DECISION DELEGATED TO HEAD OF PLANNING

Application No:	H19-0967-22	Applicant:	Green Contractors Ltd.
Proposal:	Erection of 4 bed detached dwelling		
Location:	Adj. Rose Cottage South Eau Bank Throckenholt		
Terminal Date:	14th March 2023

CASE OFFICER ASSESSMENT

Project:	New House
Client:	Rebeca Zdroba
Address:	Rose Cottage South Eau Bank Throckenholt PE12 0QW
Drawing Title:	Site Plan
Drq No:	03
Scale:	1:200 @ A3
Date:	August 2022

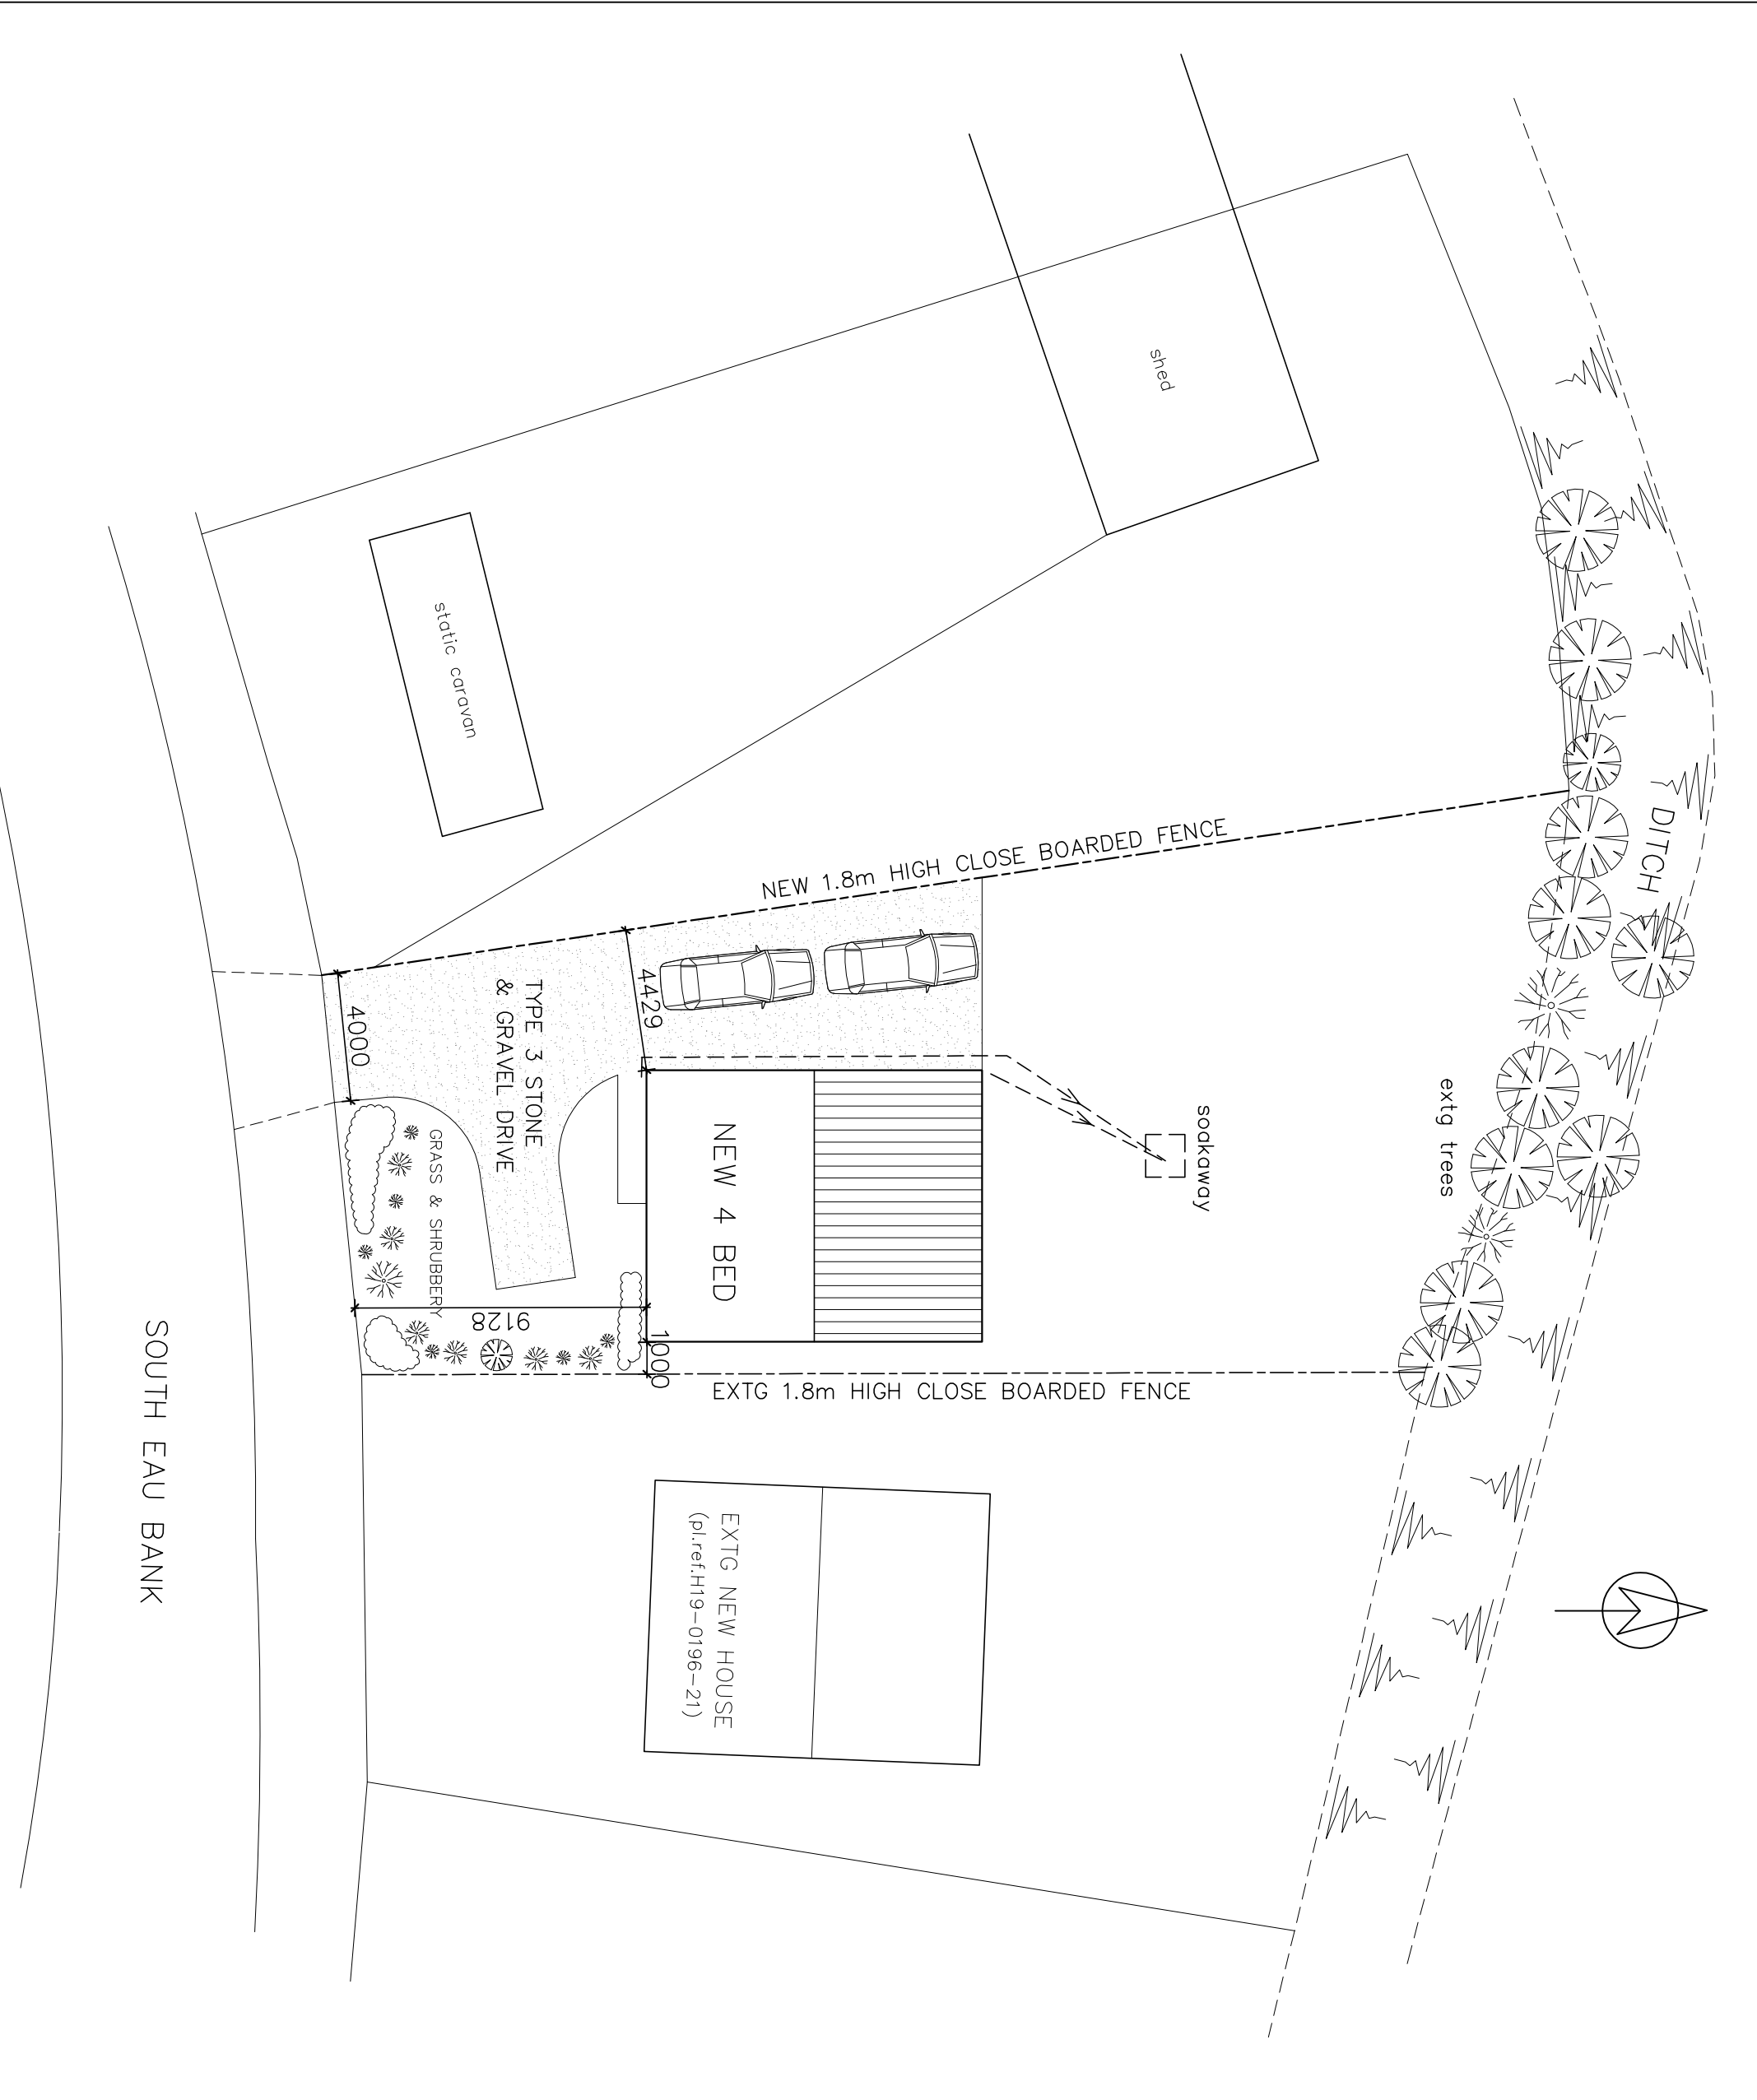
The site is at a lower level than the highway so would require an inclined driveway, like the plot to the east. There is adequate parking on site for three vehicles. LCC Highways has been consulted and has concluded that the proposed development would not be expected to have an unacceptable impact upon highway safety and does not wish to object to this planning application.

In respect of drainage, foul water would be disposed of to a treatment plant. Surface water would be disposed of to a soakaway at the rear which appears to be 9 metres from a drain running along the rear boundary. Separate drainage consent would be required from the North Level Internal Drainage Board if this was not the case.

Project:	New House
Client:	Rebeca Zdroba
Address:	Rose Cottage South Eau Bank Throckenholt PE12 0QW
Drawing Title:	Proposed Elevations
Drq No:	01
Scale:	1:100 @ A3
Date:	August 2022

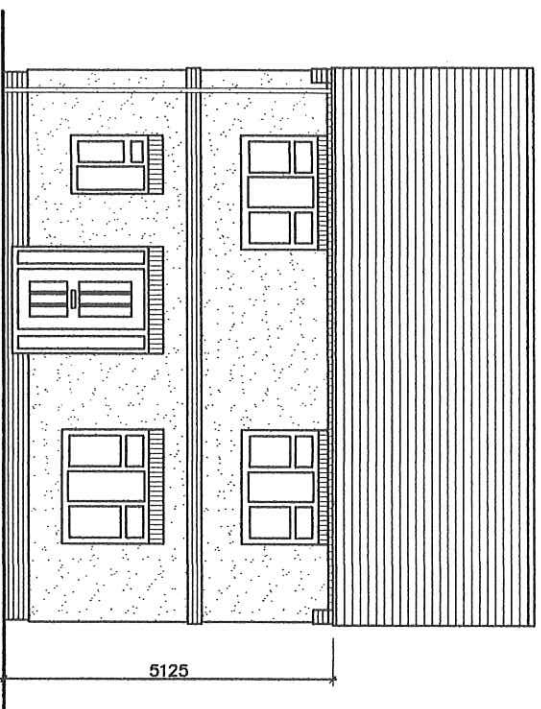
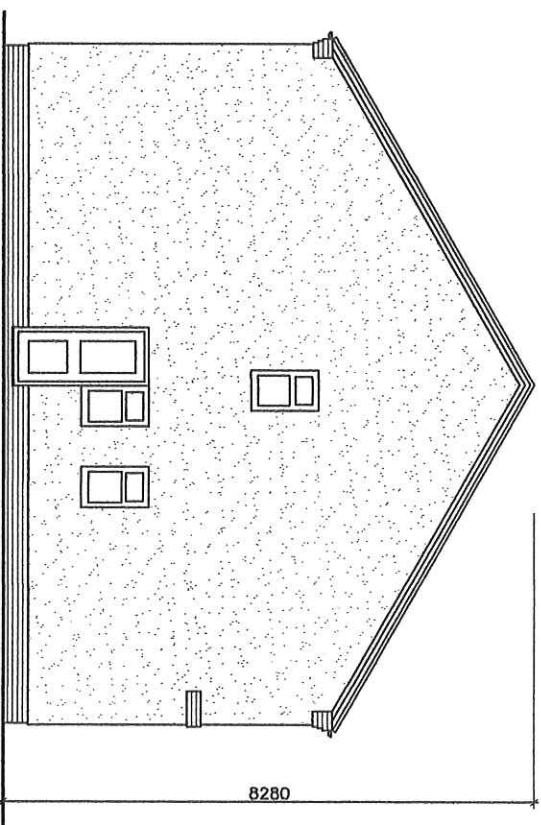
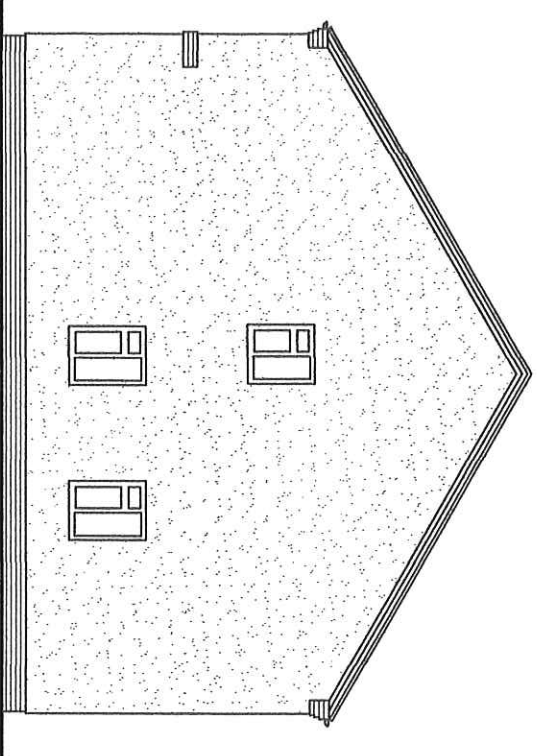
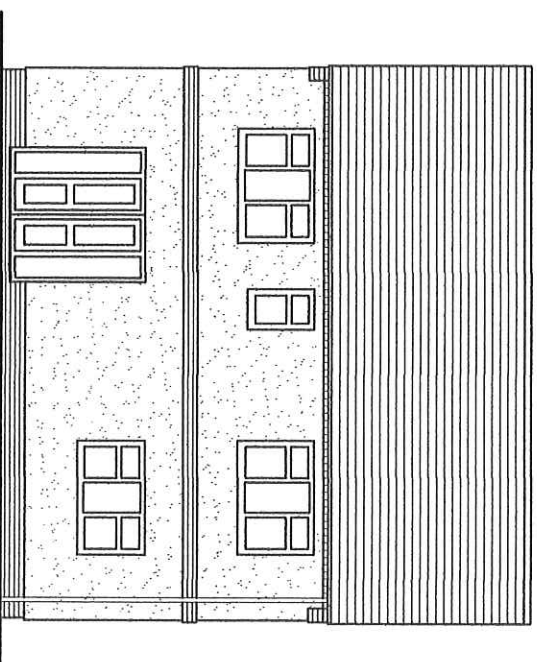
The proposed house would have white rendered walls with red detail brickwork and grey slate roofing tiles, with uPVC windows. The general locality has an eclectic mix of house types and materials. A 3-bed house to the East has been constructed in red brickwork with a Marley Modern smooth grey roof. However, Rose Cottage itself is cream rendered, and a bungalow on the junction of Hall Gate Road has white render. It is considered that the proposed house could be satisfactorily accommodated without materially harming the street scene

Regarding amenity, the new house to the East has a utility door and first floor landing window on its western elevation. The proposed house has secondary lounge and dining room windows on its eastern elevation at ground level and a bathroom window at first floor level. Bedroom windows at the rear would overlook the neighbouring garden at an oblique angle, typical of a normal frontage situation. It is considered that the amenity of nearby residents/occupiers would not be materially harmed in terms of overlooking, lack of privacy, overshadowing, overbearing effect, noise and disturbance, etc.
